APPLICATION NO: 23/00788/FUL/ADDINF

DESCRIPTION: Proposed erection of part single part three storey side extension.

LOCATION: 88 Fernbank Road Ascot Berkshire

Side Elevation 1:100

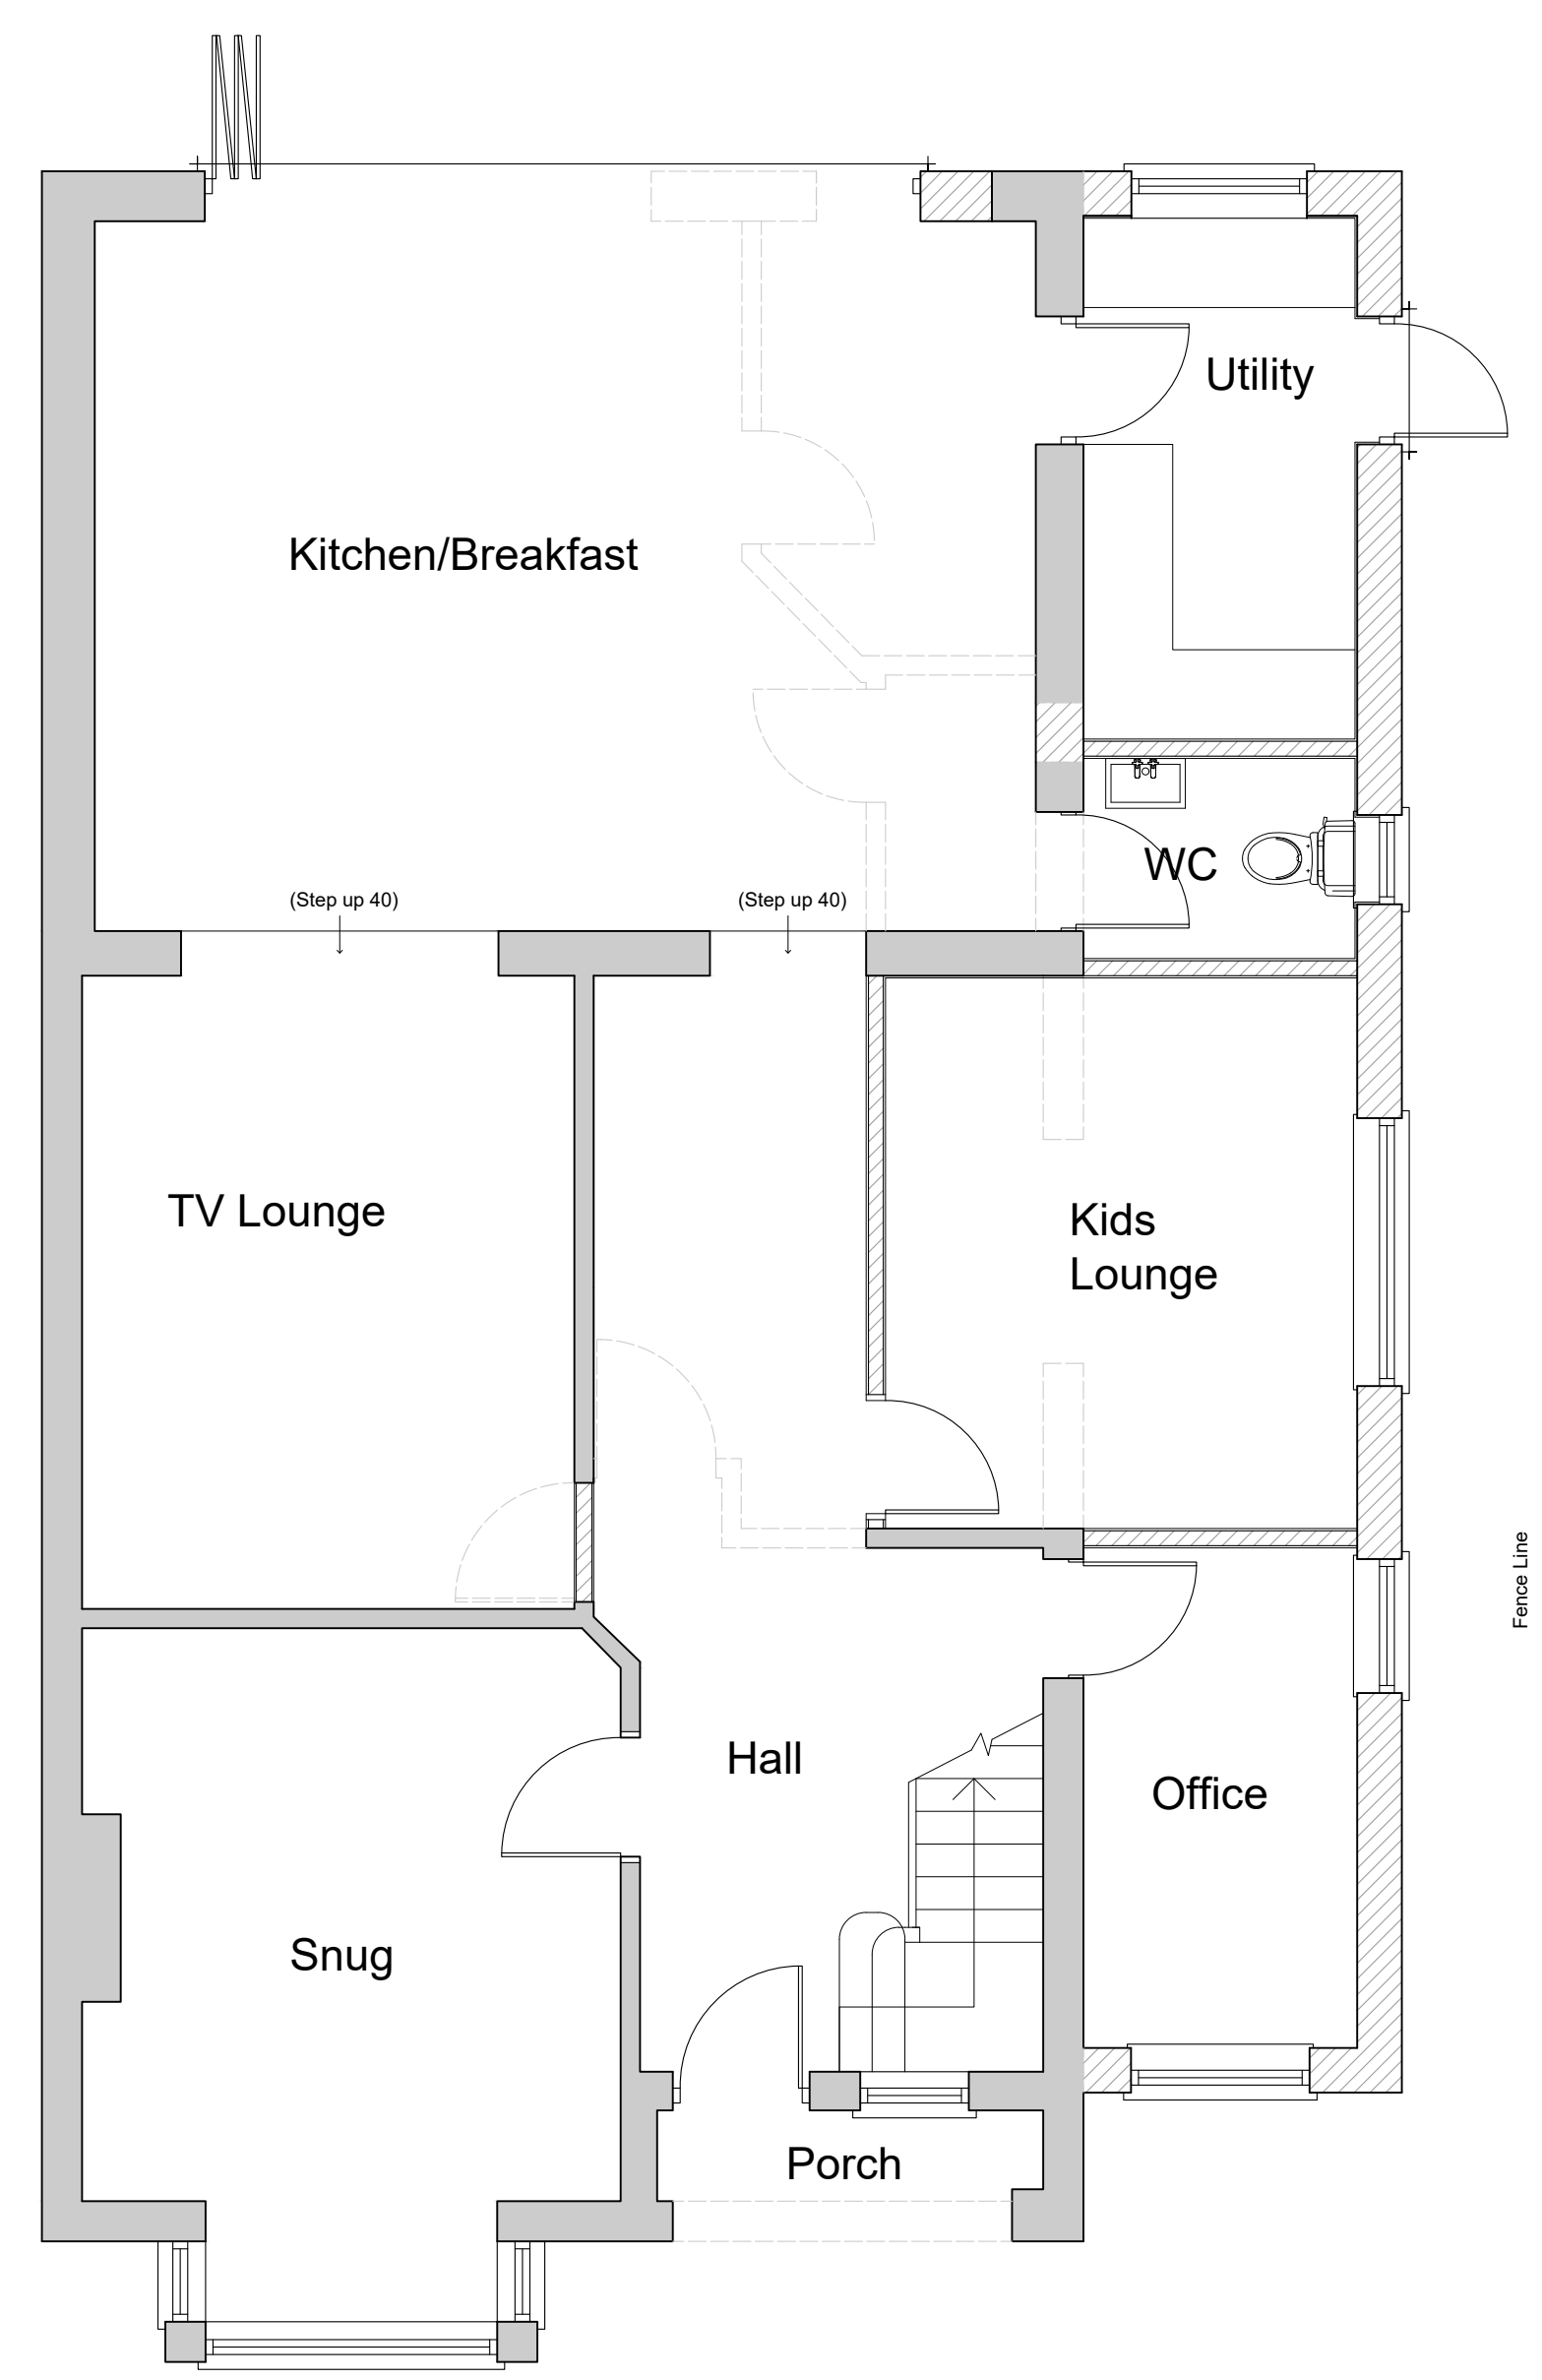
- 1 A fee of £206 is required for your application. The required fee can be paid by calling customer service on 01344 352 000 or online via our payments forms using the development control (planning) option.
- 2 Please show the railings of the Juliet balcony on the Proposed side elevations.
- 3 Please submit a parking plan.
